CITY OF ALBUQUERQUE

**RE: FNCH Clinic
5110 Copper Ave NE
Grading and Drainage Plan
Engineer's Stamp Date: 10/10/22
Hydrology File: K17D118**

Based upon the information provided in your submittal received 10/10/22, the Grading & Drainage Plan is not approved for Building Permit. Following comments need to be addressed for approval of the above referenced project:

GRADING & DRAINAGE PLAN
1" = 20'-0"

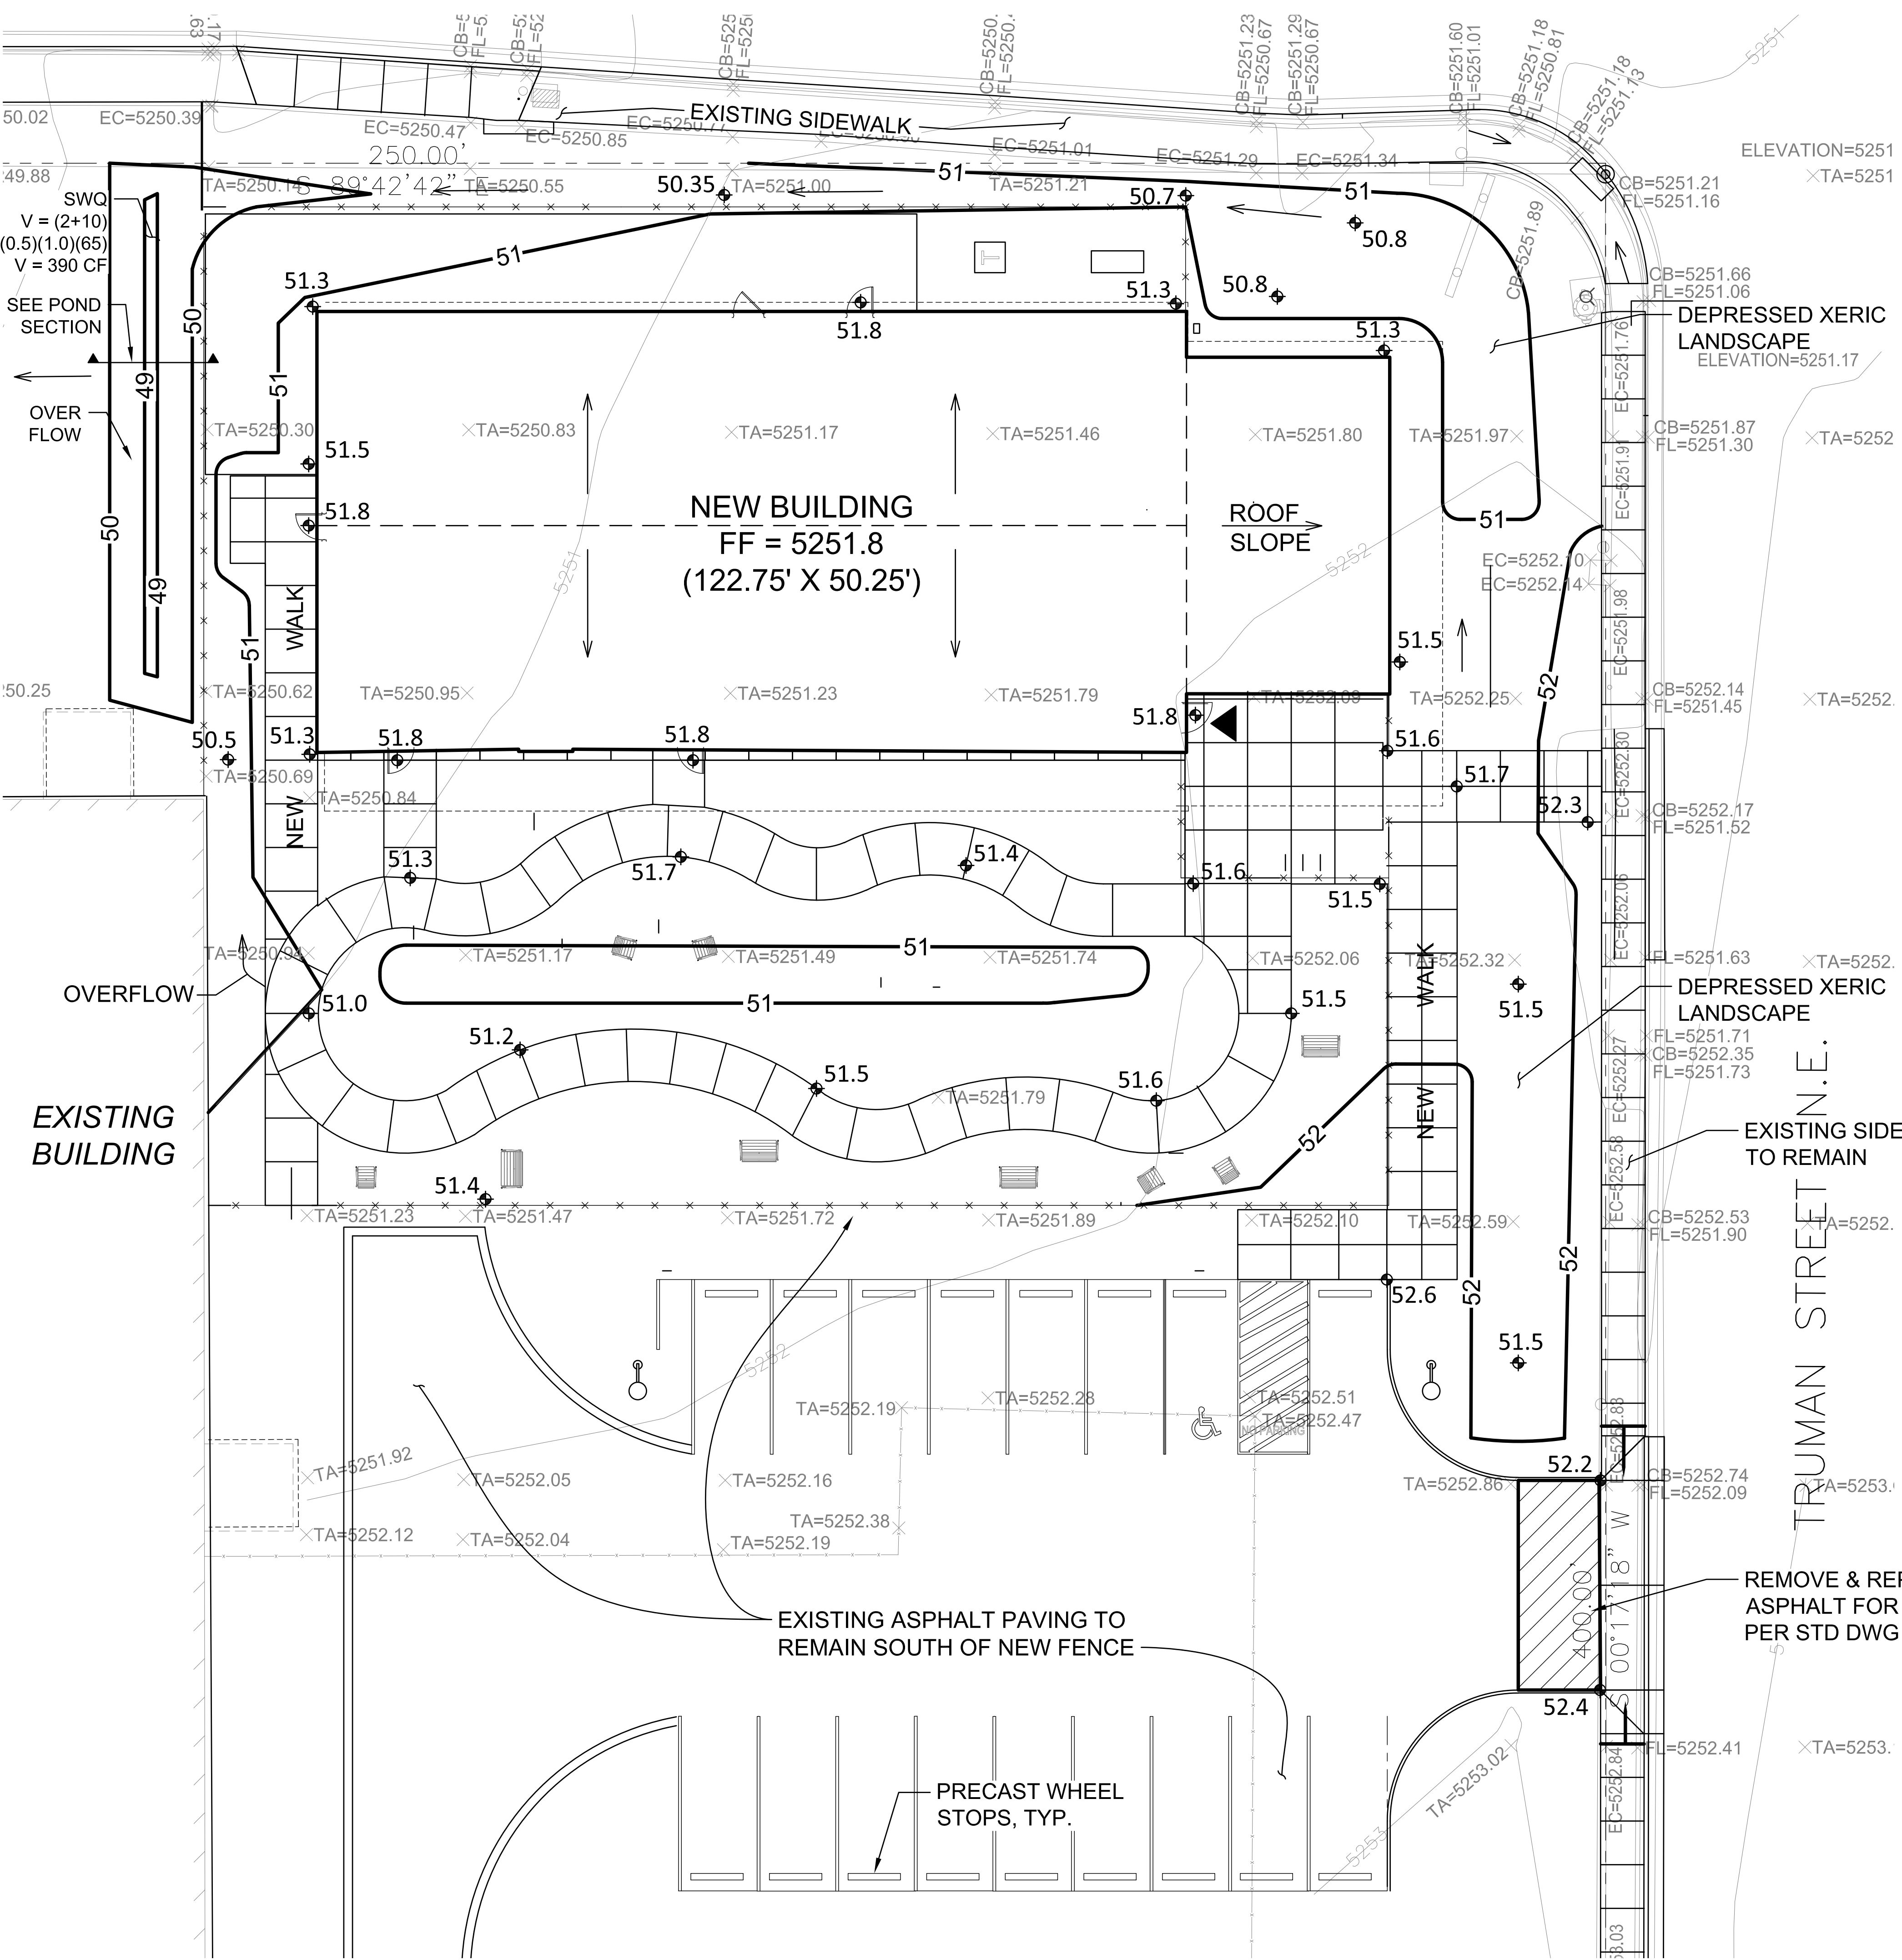
1. Please provide dimensions of the proposed building. It looks like the scale is wrong since the building would be almost as wide as the parcel's width according to the current scale on the plan.
2. Provide overflow direction to the pond west of the building. Sidewalk culvert(s) will be required if it overflows to the north. Or make the west bank lower if you want it overflows to the west.
3. Add a spot elevation at the narrowest point to the pond north of the building.
4. SO-19 approval is required.
